ENG-SP20003-R3-PDR-redlines.pdf Markup Summary

Subject: EPC ENG Review
Page Index: 1
Date: 4/6/2021 9:18:29 AM
Author: dsdrice
Color: ■
Layer:
Space:
Page Label: 1

See comment letter also.

# STERLING RANCH PHASE 2 PROPOSED DRAINAGE MAP

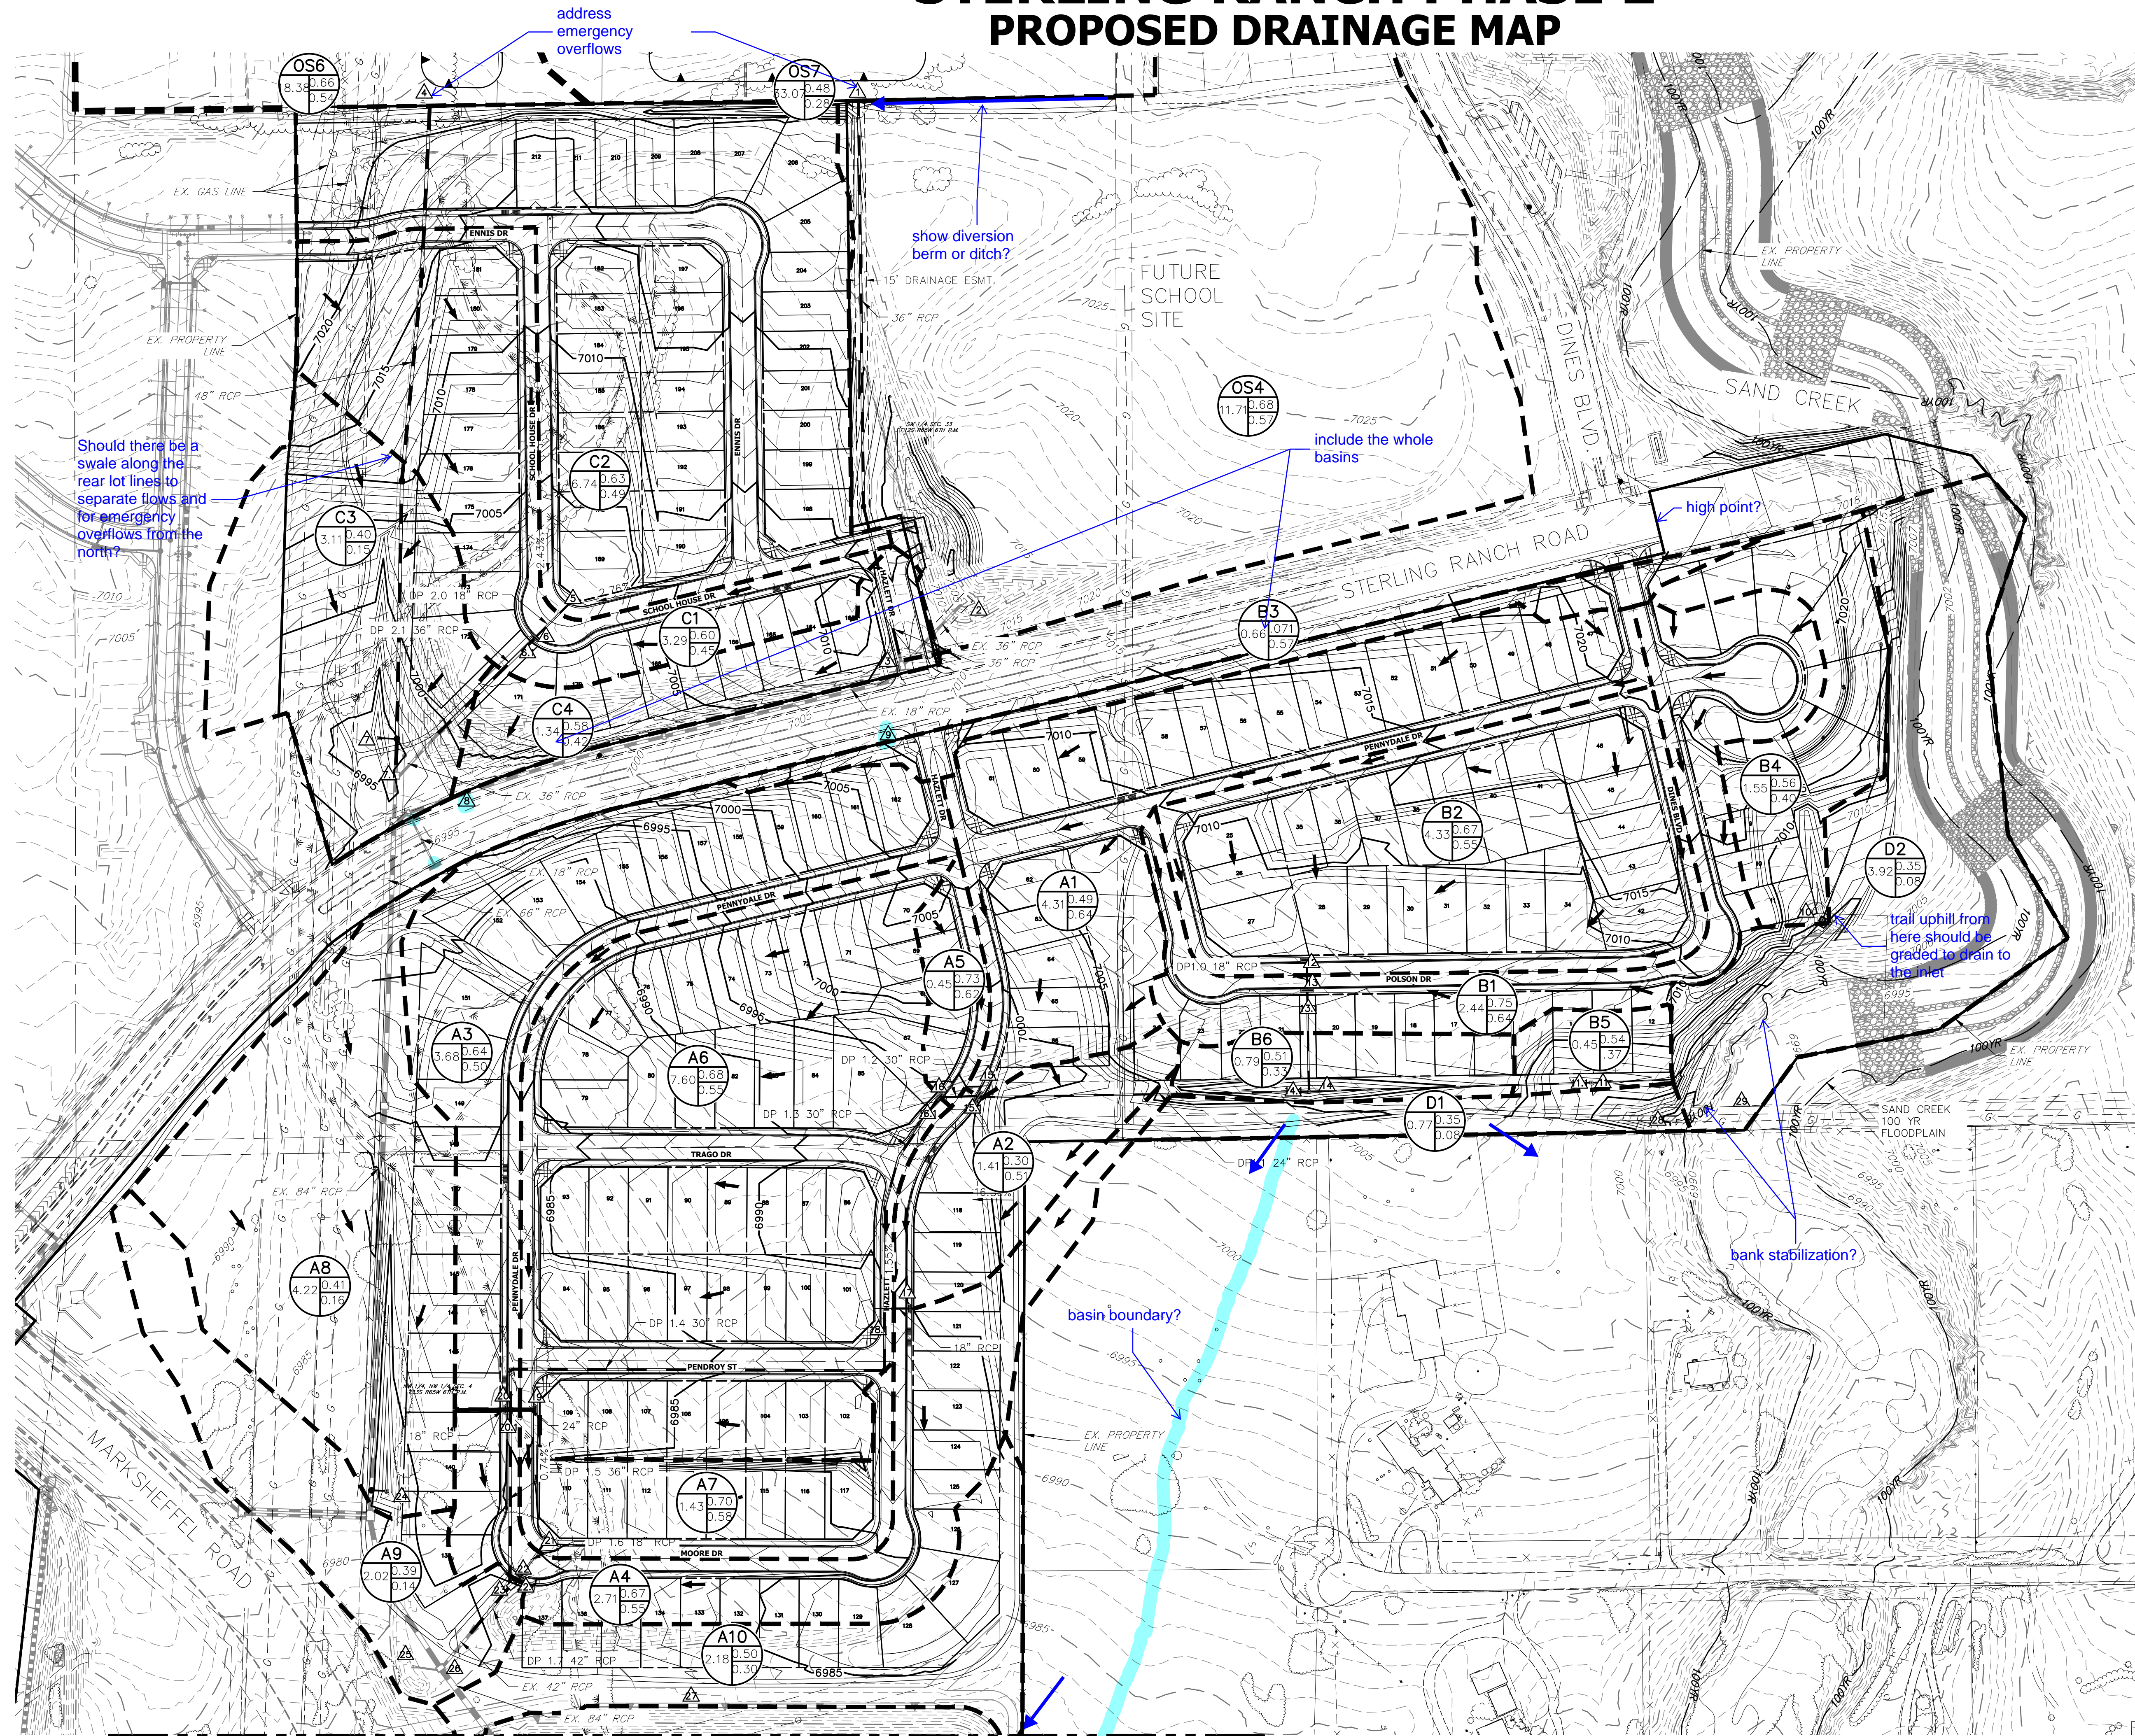
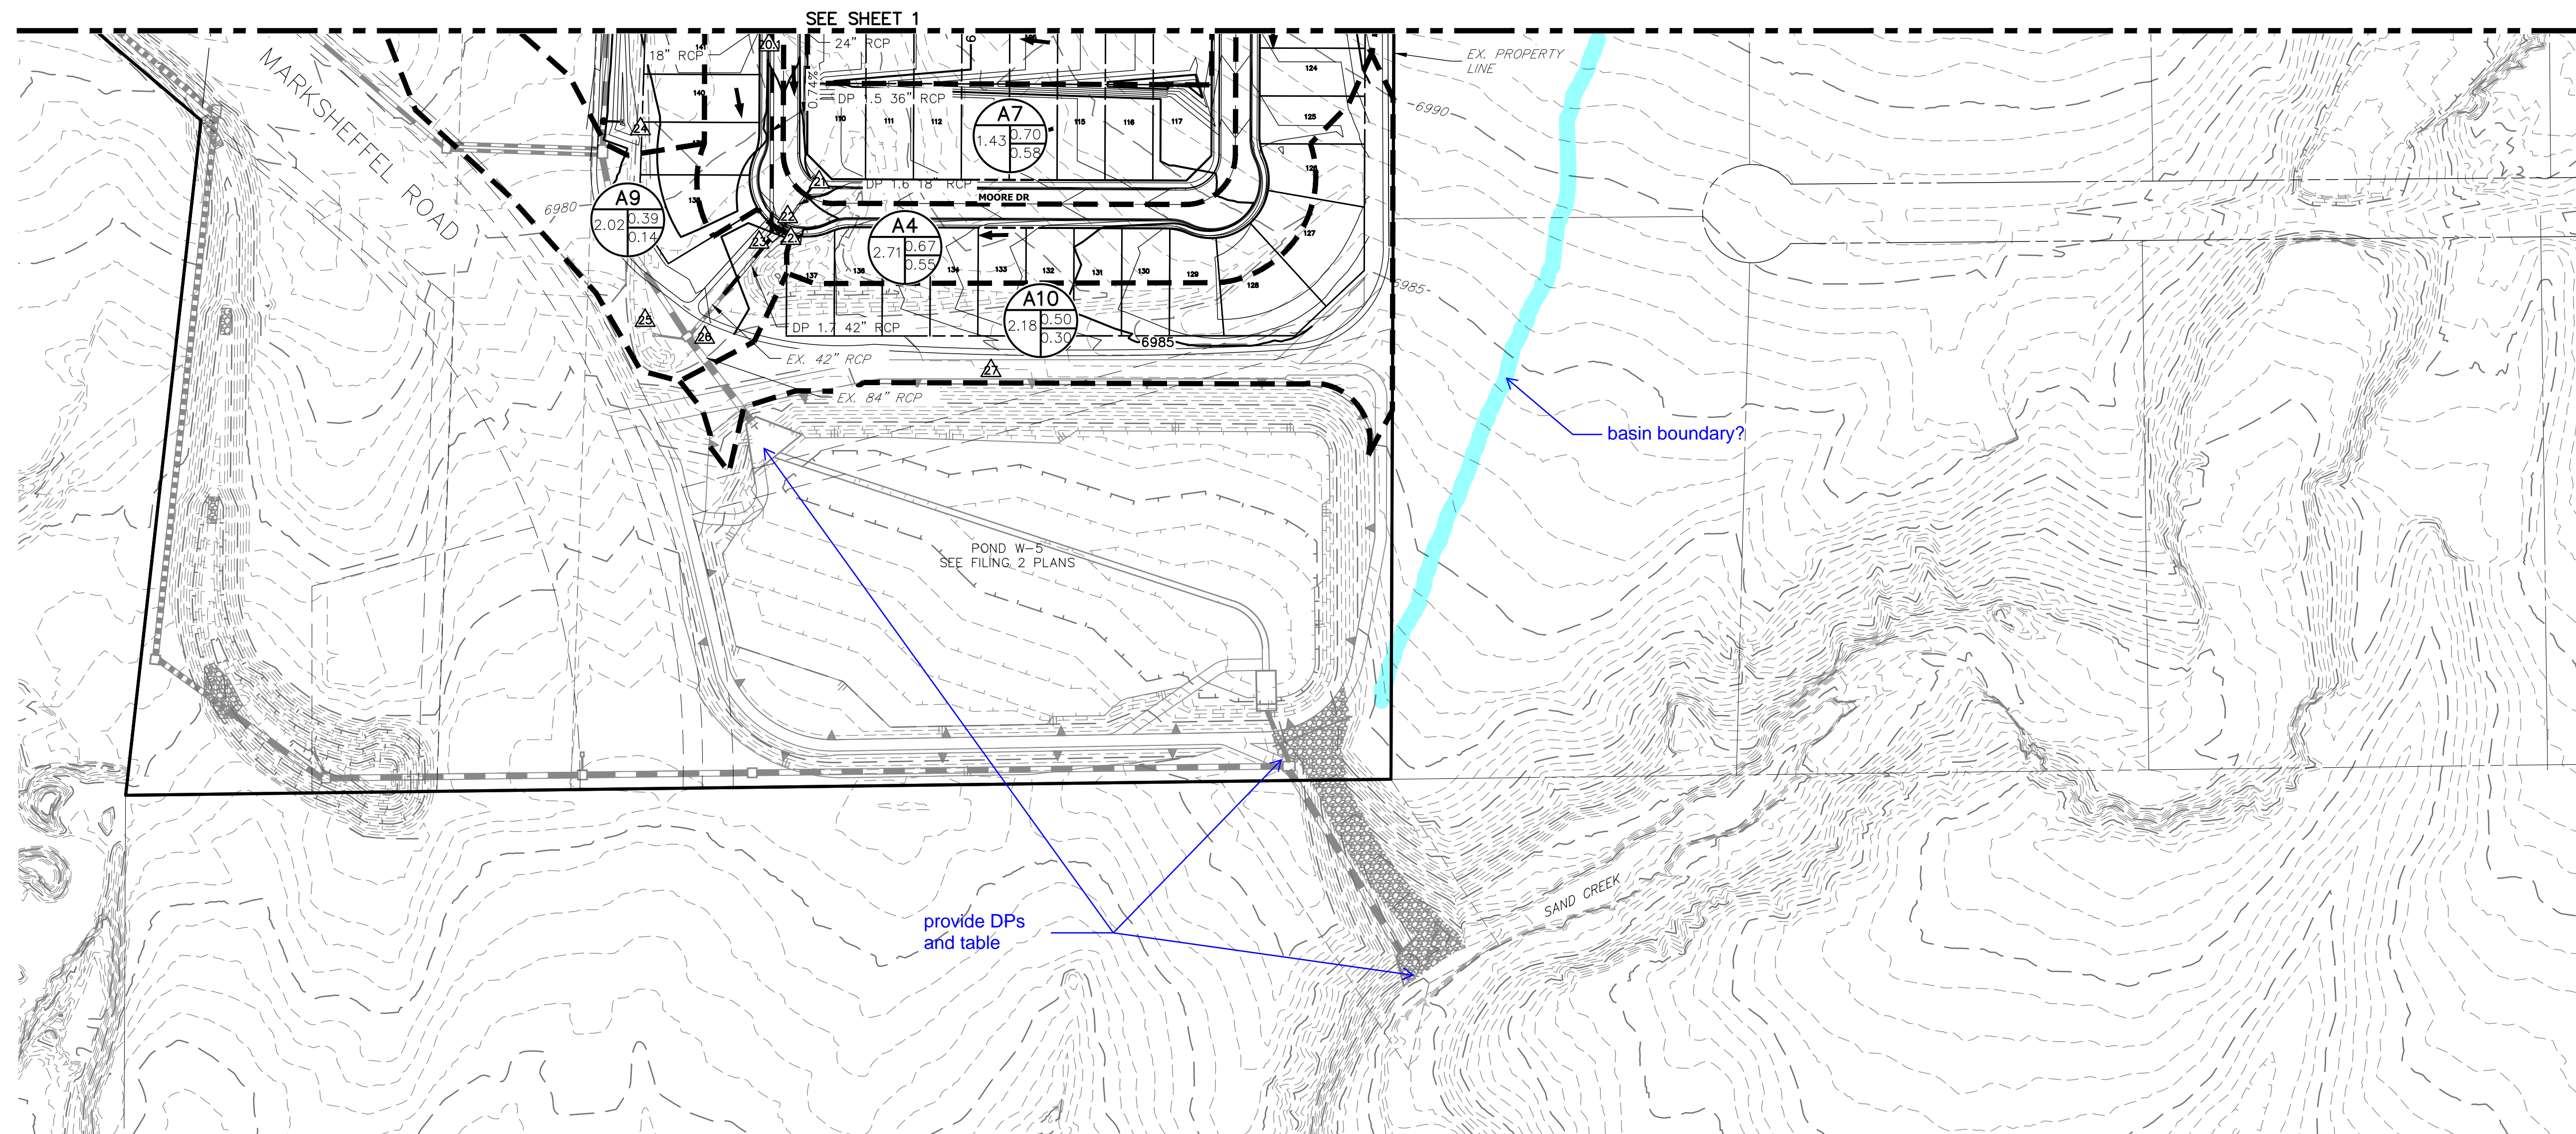
bank stabilization?

show diversion berm or ditch?

Also provide DP summary

basin boundary?

high point?

include the whole basins

address emergency overflows

trail uphill from here should be graded to drain to the inlet

Should there be a swale along the rear lot lines to separate flows and for emergency overflows from the north?
